**EL PASO COUNTY PLANNING AND  
 COMMUNITY DEVELOPMENT  
 DEPARTMENT**

**STORMWATER MANAGEMENT PLAN CHECKLIST  
 Mountain's Edge SF-20-001**

Revised: July 2019		Applicant	PCD
17	SWMP Map to include: <b>Reviewed GEC Plan_v2</b>	<b>Yes</b>	
17a	construction site boundaries	<b>Yes</b>	✓
17b	flow arrows to depict stormwater flow directions	<b>Yes</b>	✓
17c	all areas of disturbance	<b>Yes</b>	✓
17d	areas of cut and fill	<b>Yes</b>	✓
17e	areas used for storage of building materials, soils (stockpiles) or wastes	<b>Yes</b>	✓
17f	<b>location of any dedicated asphalt / concrete batch plants</b>	<b>N/A</b>	✗
17g	location of all structural control measures	<b>Yes</b>	✓
17h	<b>location of all non-structural control measures</b>	<b>Yes</b>	✗
17i	springs, streams, wetlands and other surface waters, including areas that require maintenance of pre-existing vegetation within 50 feet of a receiving water	<b>Yes</b>	✓
18	<b>Narrative description of all structural control measures to be used. Modifications to EPC standard control measures must meet or exceed County-approved details.</b>	<b>Yes</b>	✗

GRADING AND EROSION CONTROL DETAILS

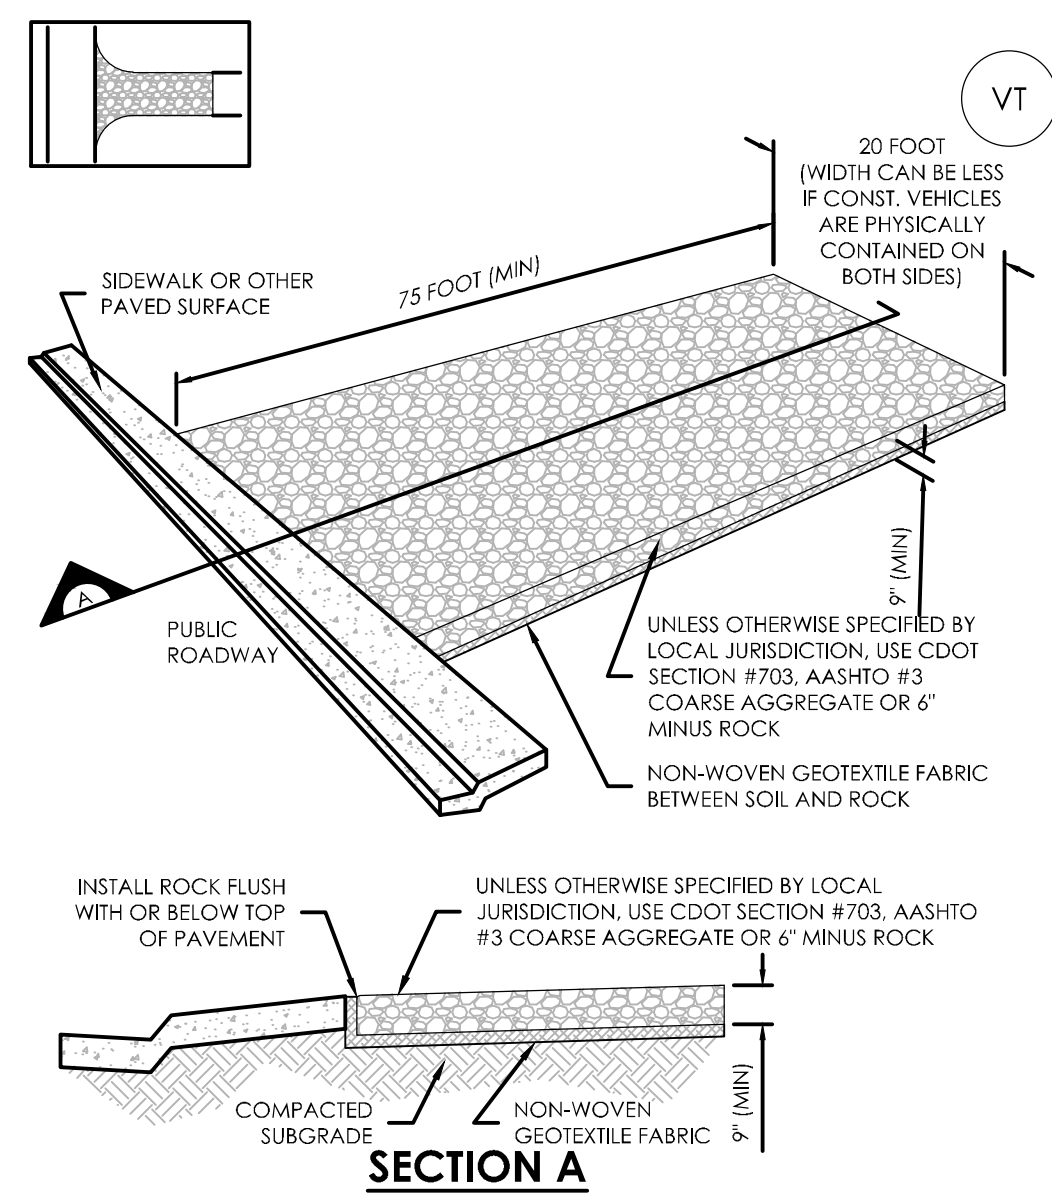
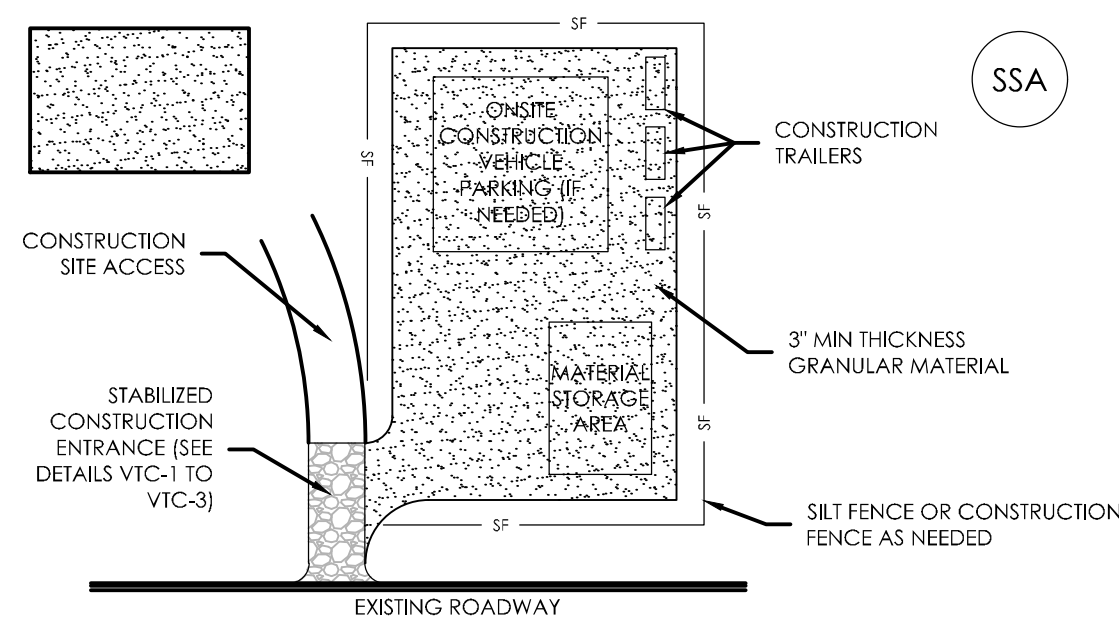
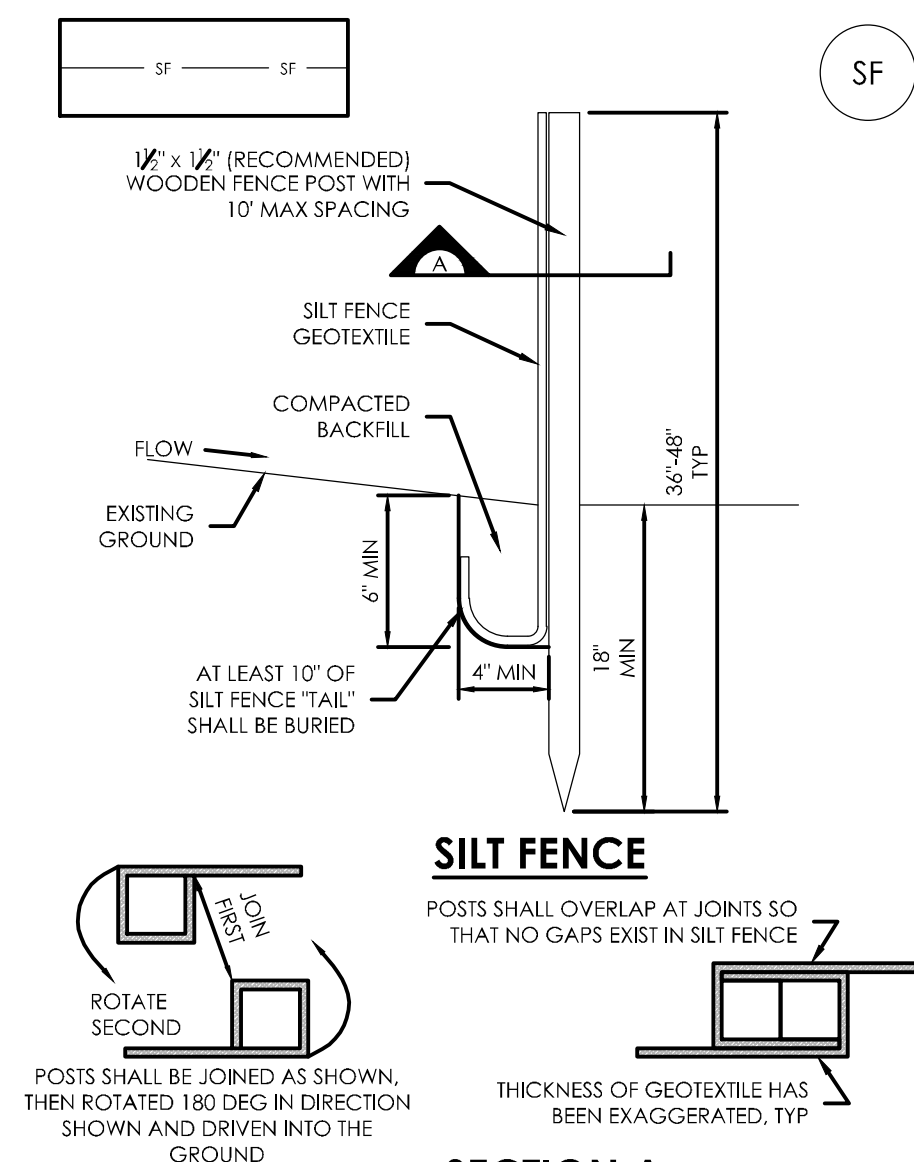
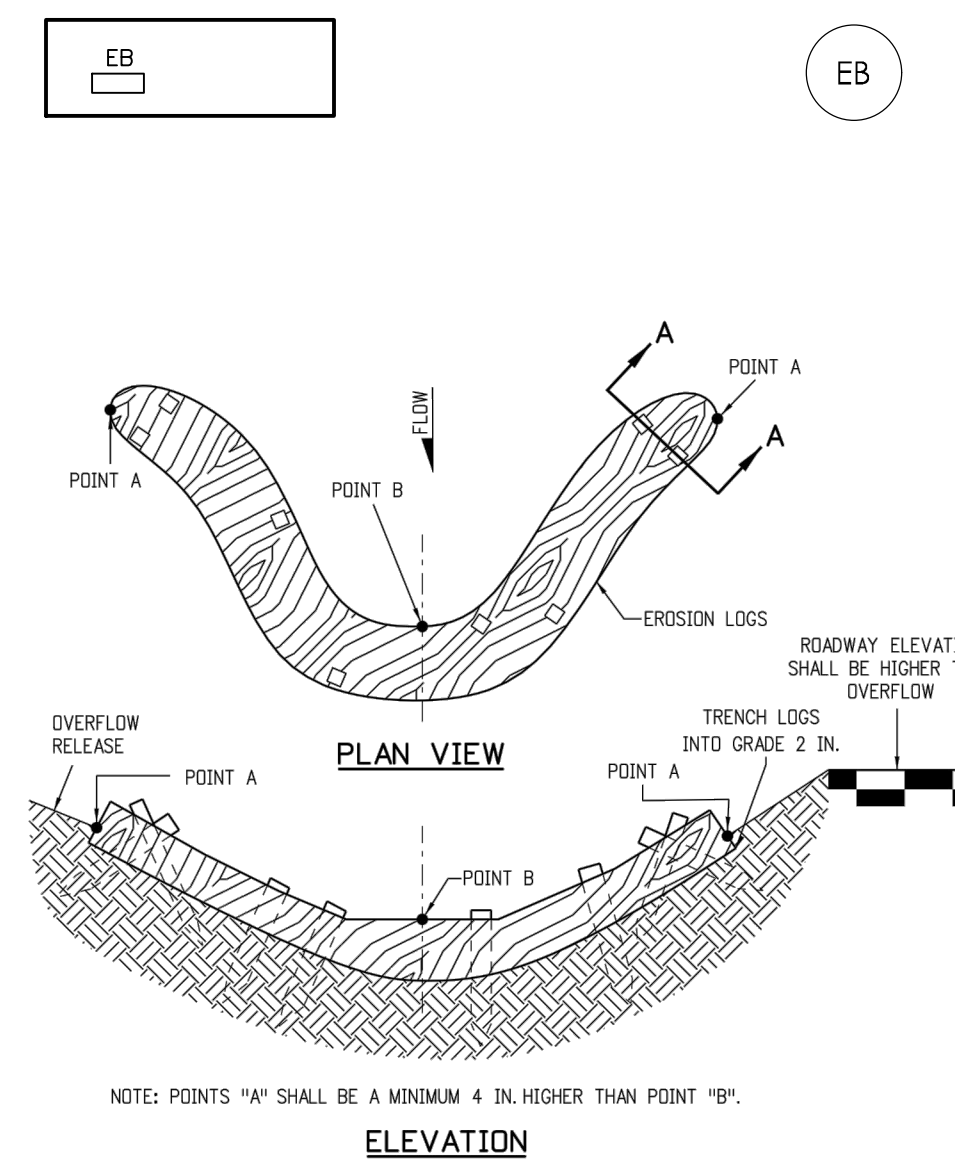
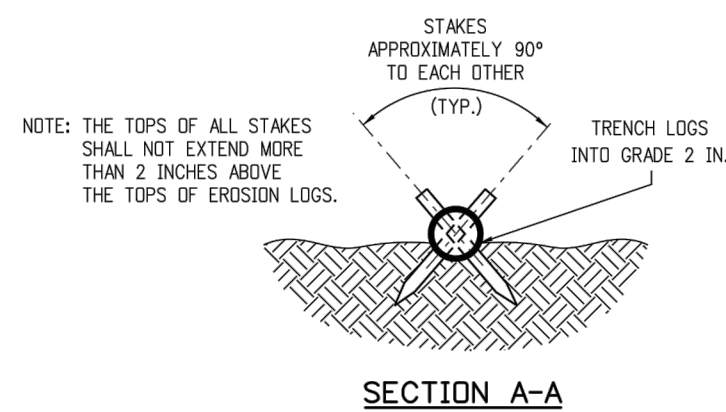
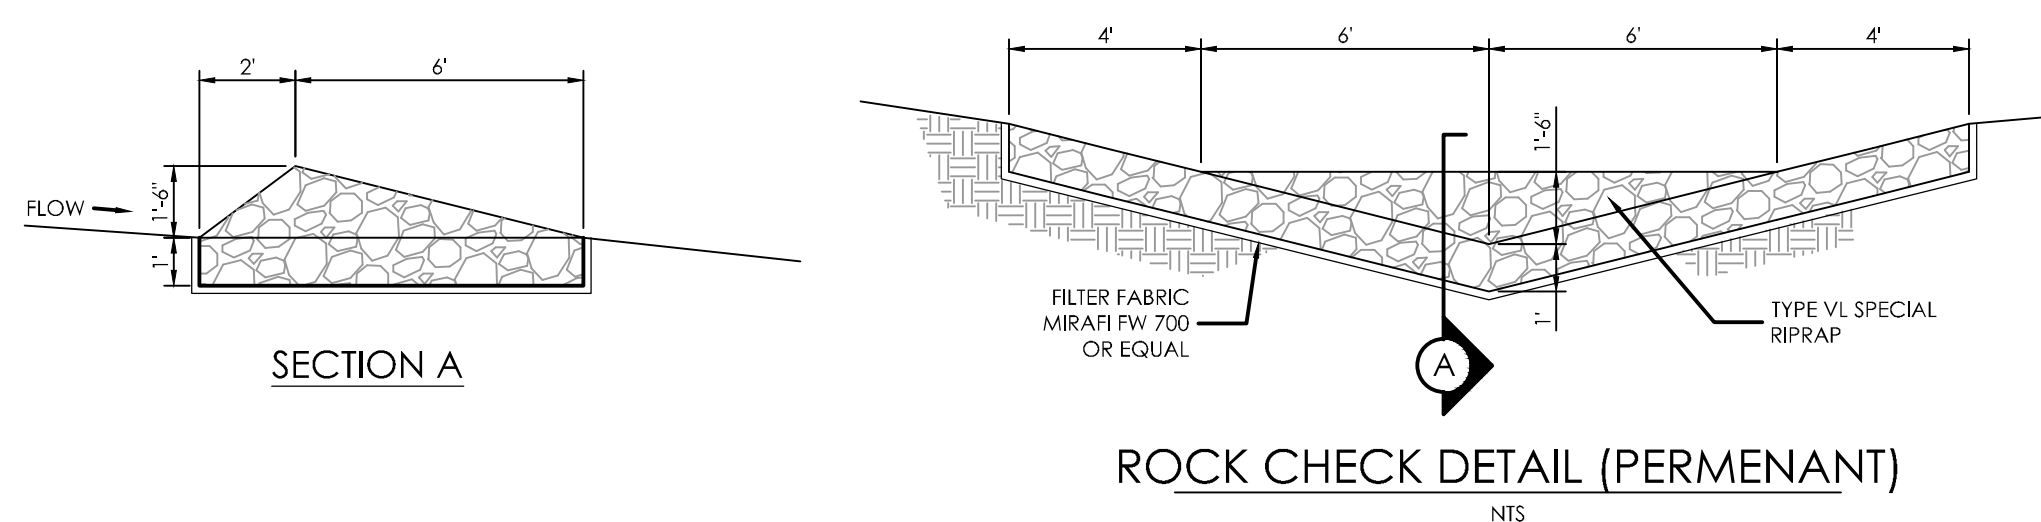
19	Description of all non-structural control measures to be used including seeding, mulching, protection of existing vegetation, site watering, sod placement, etc.	<b>Yes</b>	✓
20	<b>Technical drawing details for all control measure installation and maintenance; custom or other jurisdiction's details used must meet or exceed EPC standards</b>	<b>Yes</b>	✗
21	Procedure describing how the SWMP is to be revised	<b>Yes</b>	✓
22	Description of Final Stabilization and Long-term Stormwater Quality (describe nonstructural and structural measures to control SW pollutants after construction operations have been completed, including detention, water quality control measure etc.)	<b>Yes</b>	✓
23	Specification that final vegetative cover density is to be 70% of pre-disturbed levels	<b>Yes</b>	✓
24	Outline of permit holder inspection procedures to install, maintain, and effectively operate control measures to manage erosion and sediment	<b>Yes</b>	✓
